DECISION DELEGATED TO HEAD OF PLANNING

Application No: H14-0924-24 **Applicant:** Mr S Chapman
Proposal: Erection of Bungalow (Plot 1) - outline approval H14-1023-21
Location: Adj. 202 Spalding Road Pinchbeck Spalding
Terminal Date: 9th January 2025

PROPOSED ELEVATIONS

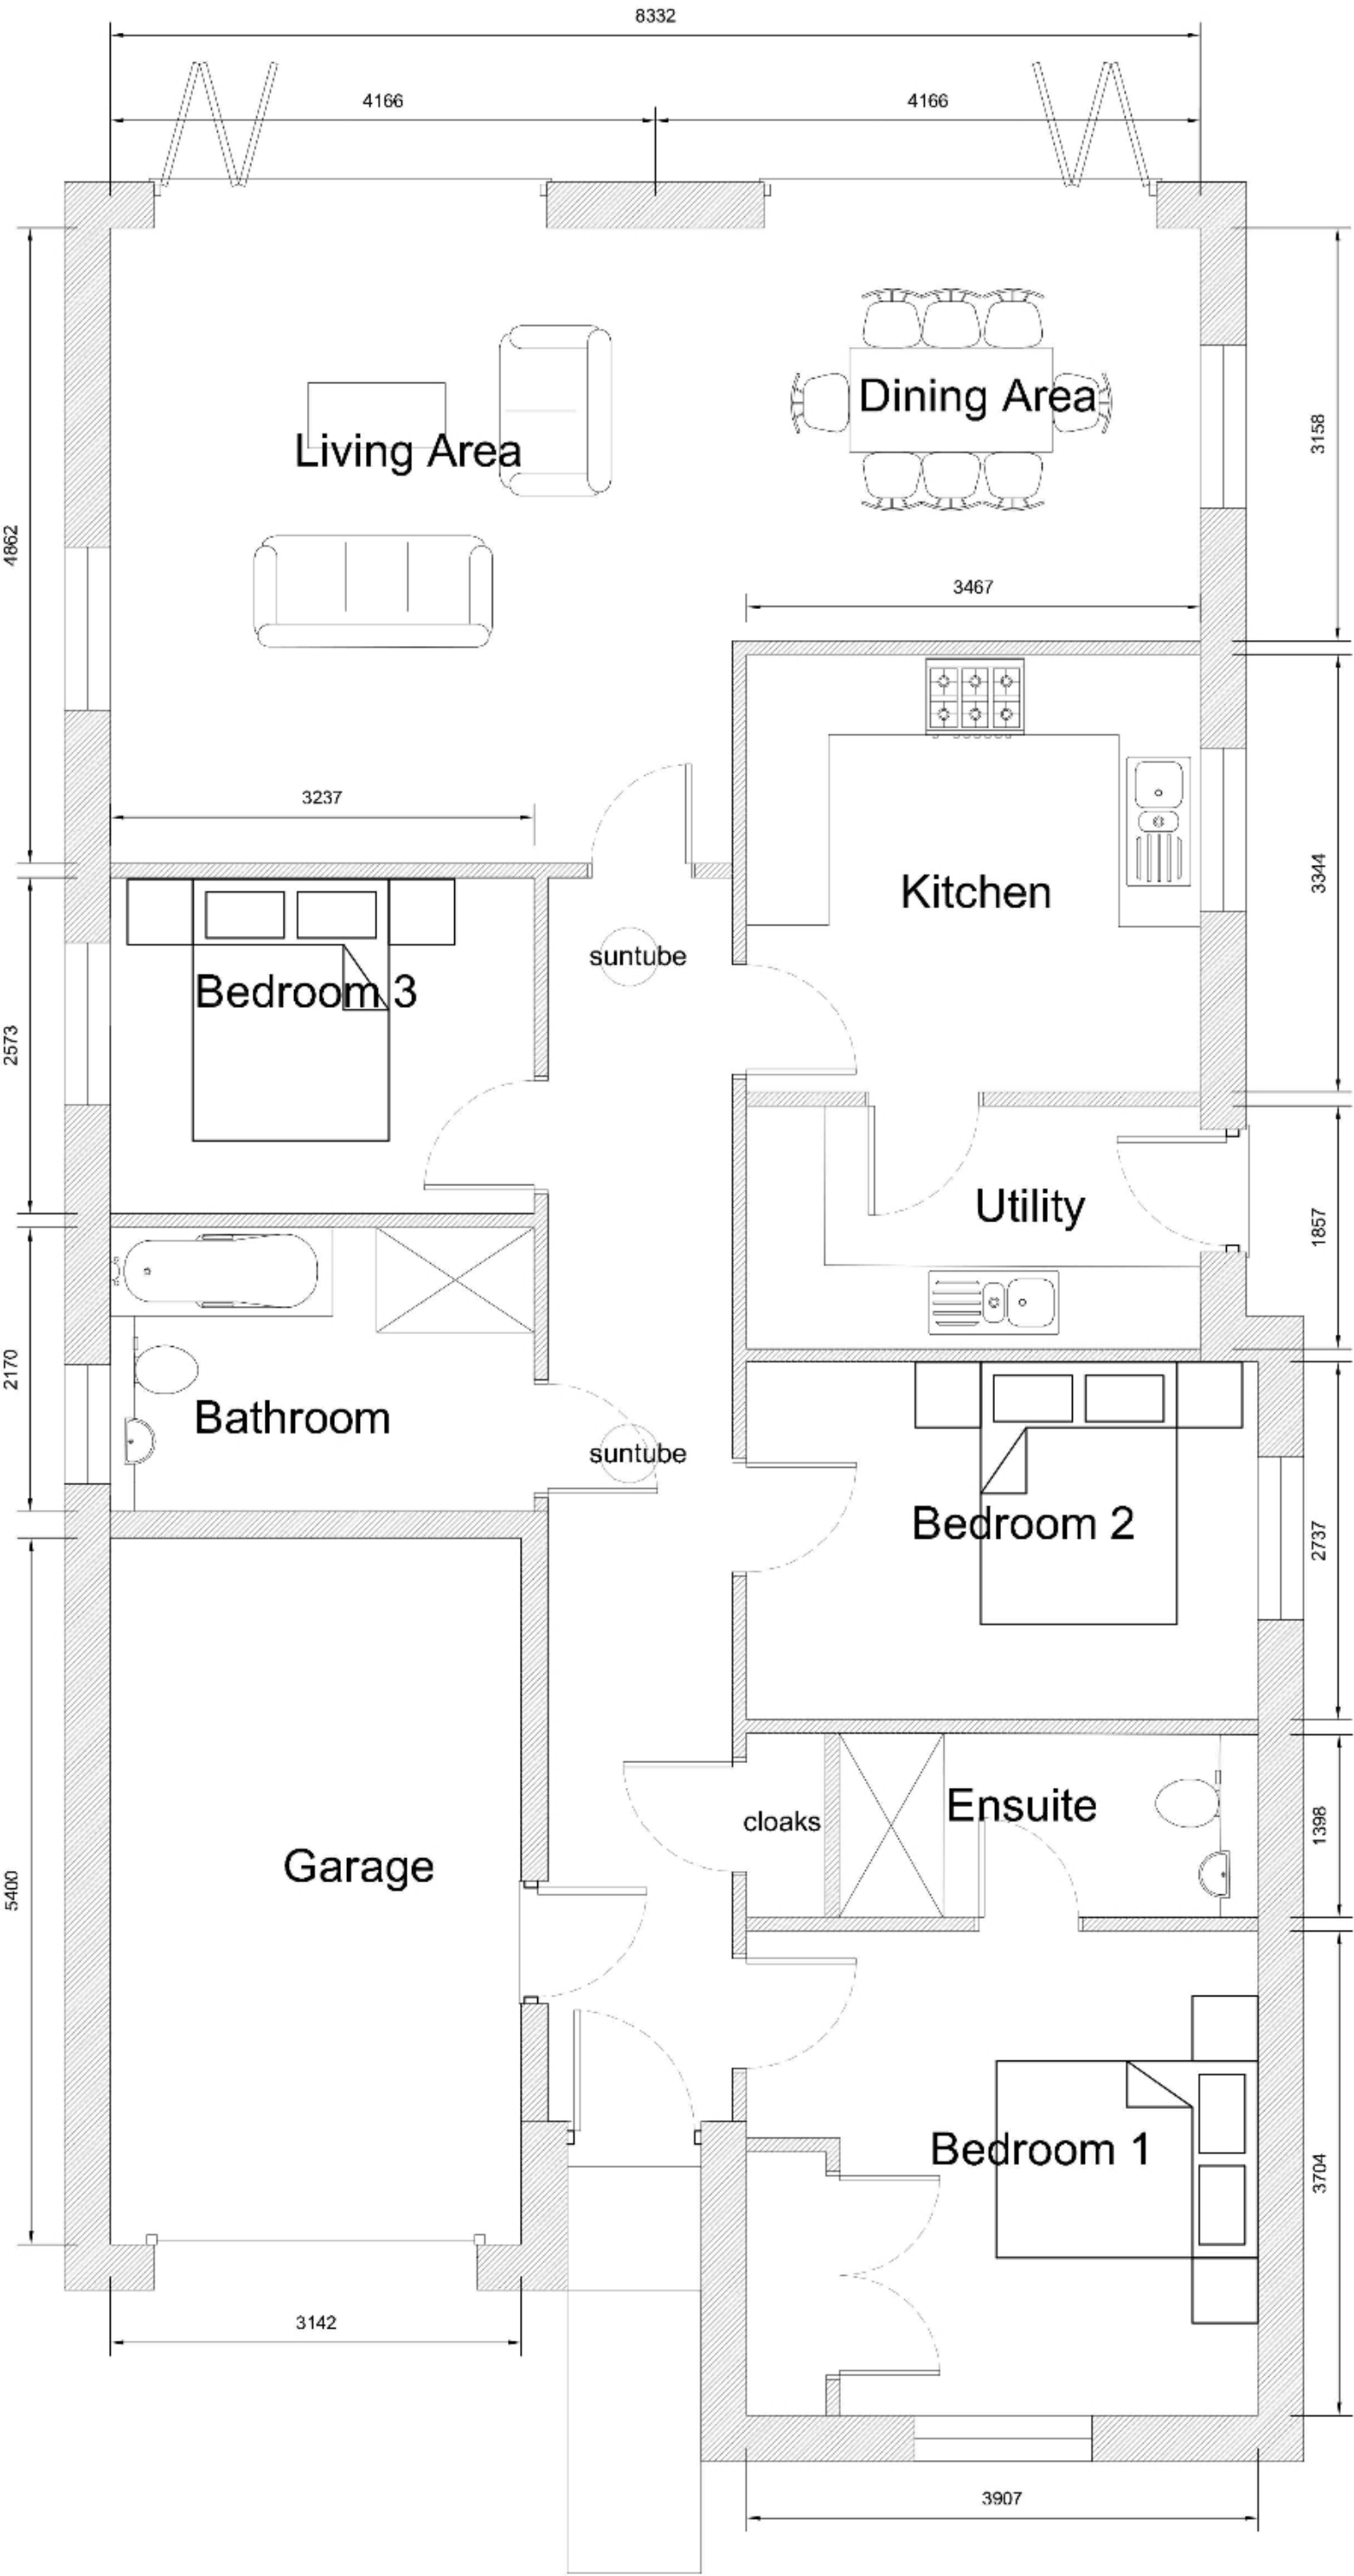
To the ridge, the bungalow would be 5300mm with a lower section being set at 4700mm. The eaves would be level throughout being 2700mm. There are multiple bungalows in the immediate area (including Plot 2) with hipped roofs creating a sense of uniformity within the site. The bungalow would also have an internal floor space of 136sqm featuring 9400mm to the front width, 9000mm rear width, 17400mm length and 16100mm on the opposite side. These measurements are also considered to be acceptable.

PROPOSED BLOCK PLAN

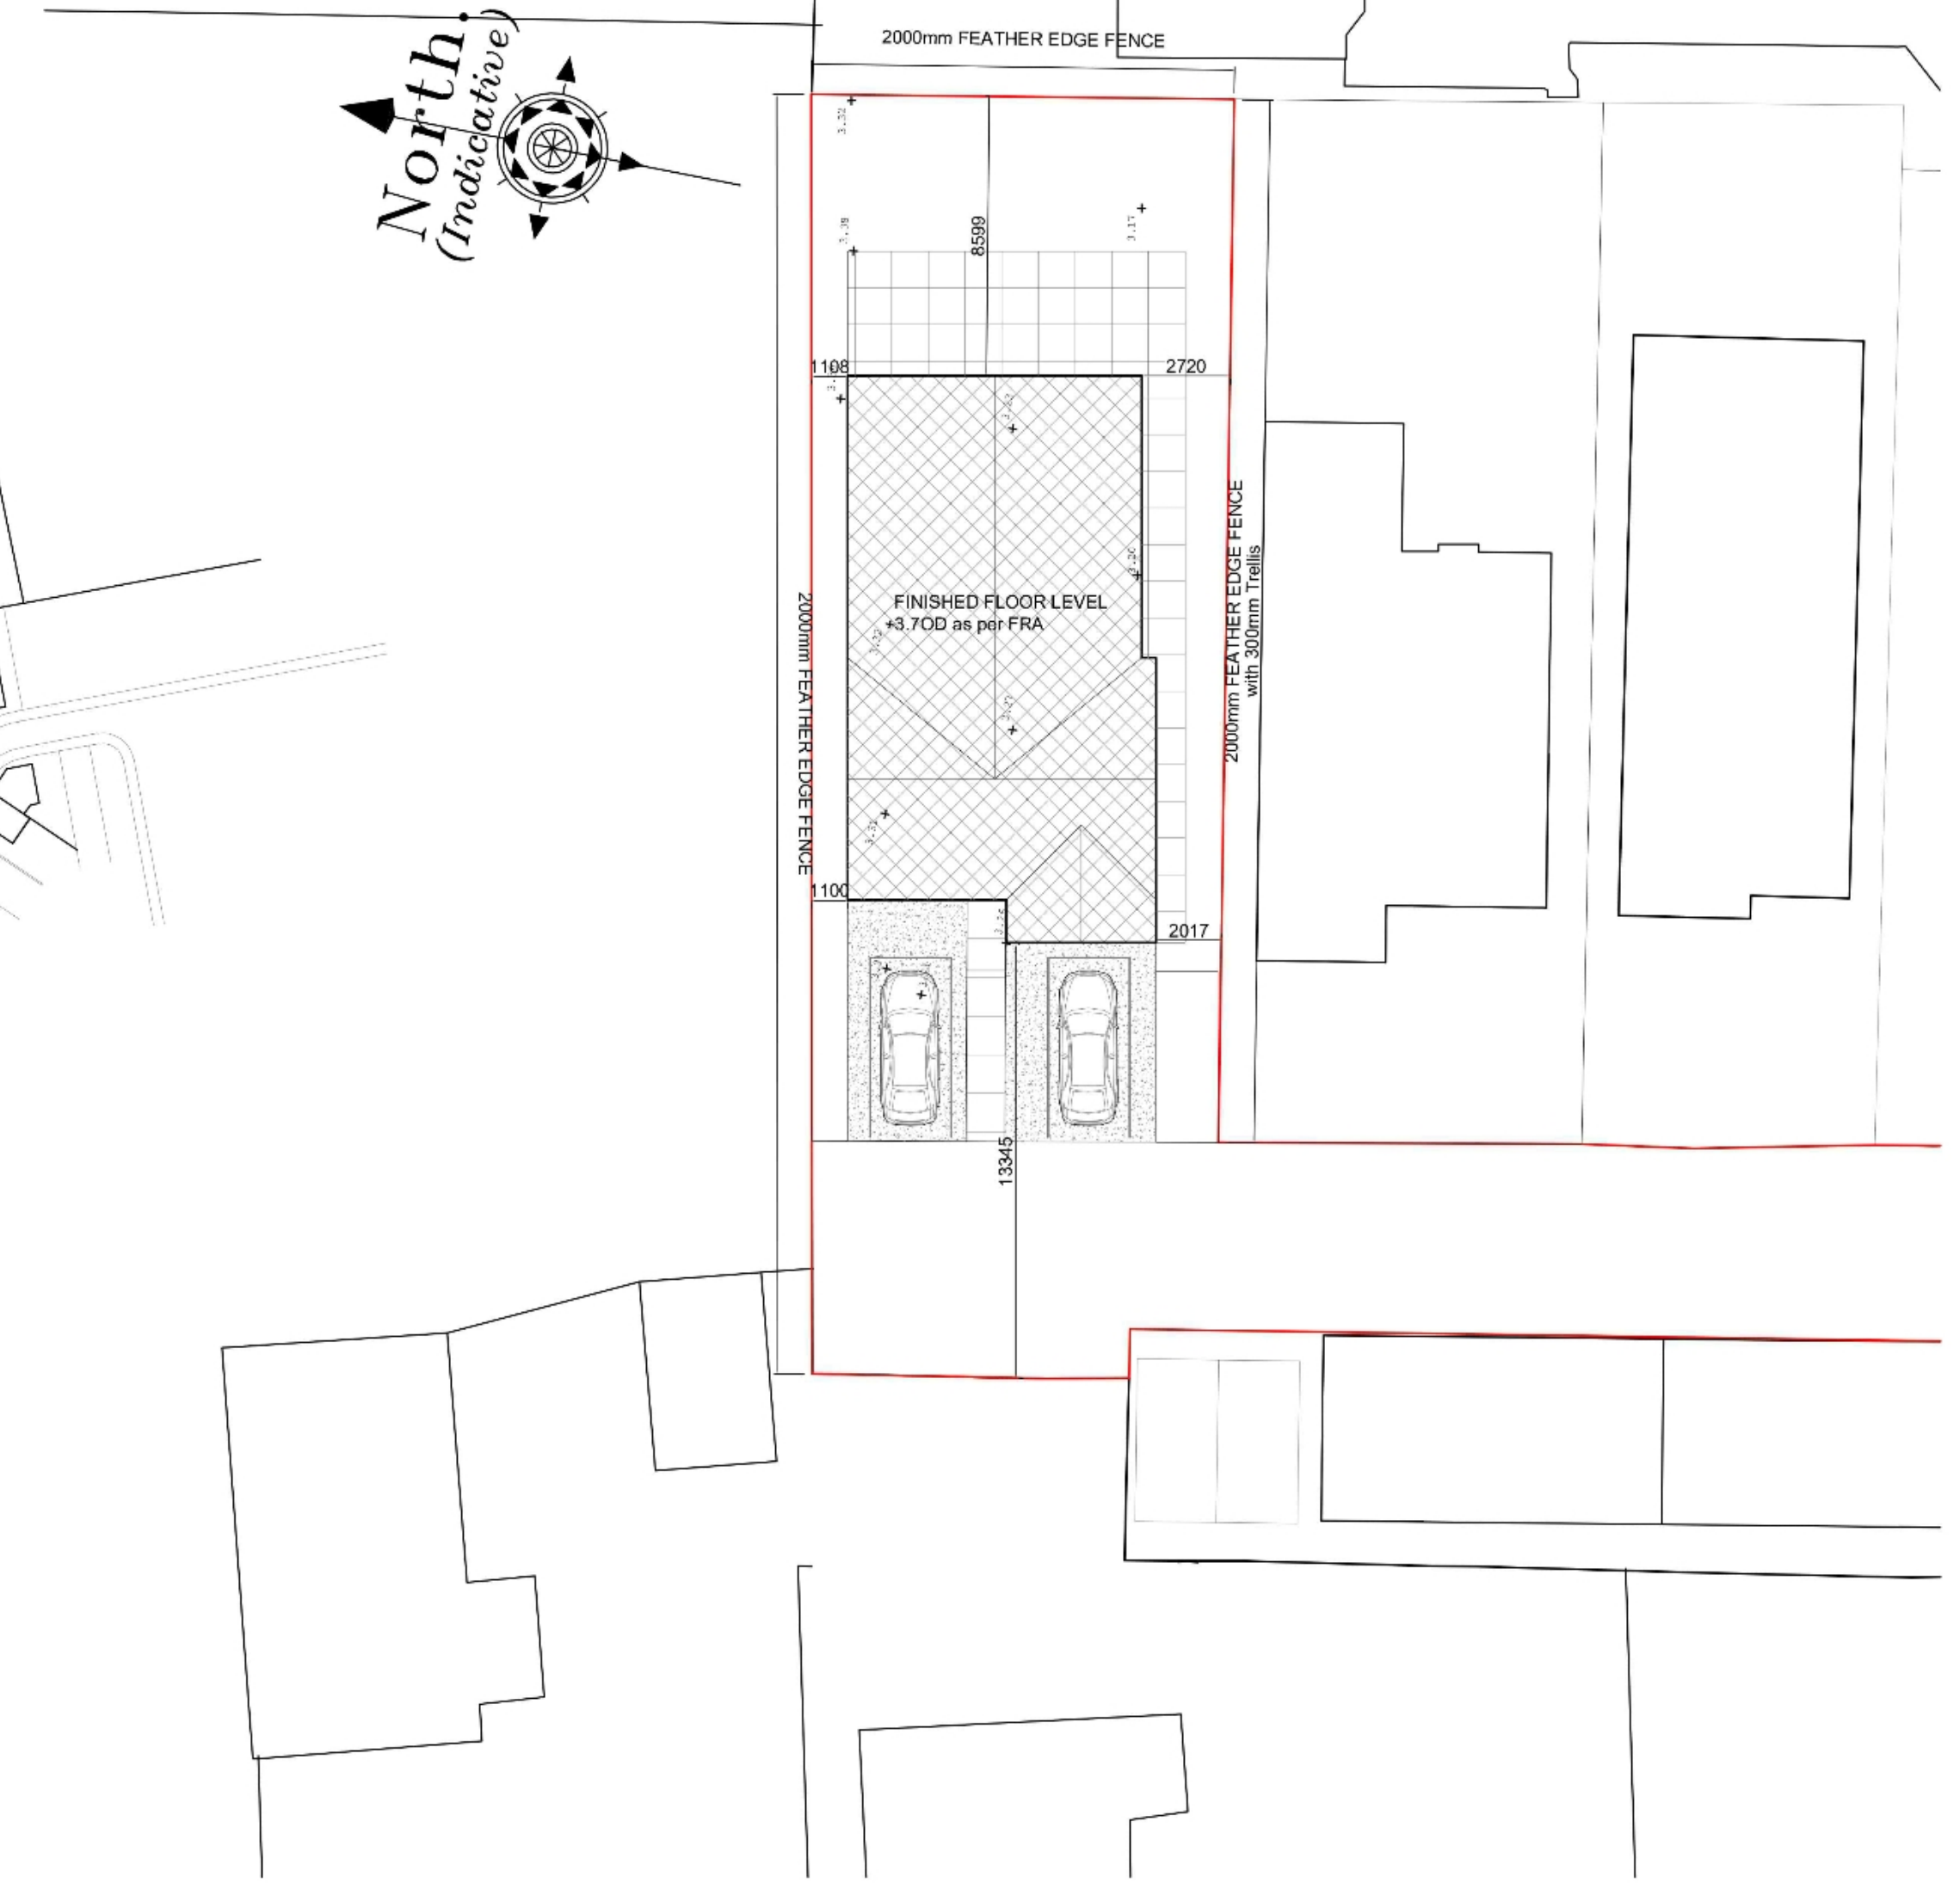
To combat any concerns, amended plans were requested and submitted adding 300mm trellising on top of a 2000mm feather edge fence on the eastern boundary. This extra 300mm would negate the dwelling being raised by 300mm internally to allow the fence to be 2000mm when viewed through the side windows inside. Although the top of the fence would only be trellis it would still negate any issues.

Plot 1 would have three bedrooms meaning it needs two vehicle parking spaces. To the front of the site, the proposed block plan outlines two clear spaces for these vehicles. It is therefore considered that they can be stored safely both off the street and off the access leading to this site. Lincolnshire County Council Highways also raised no objections to the scheme.
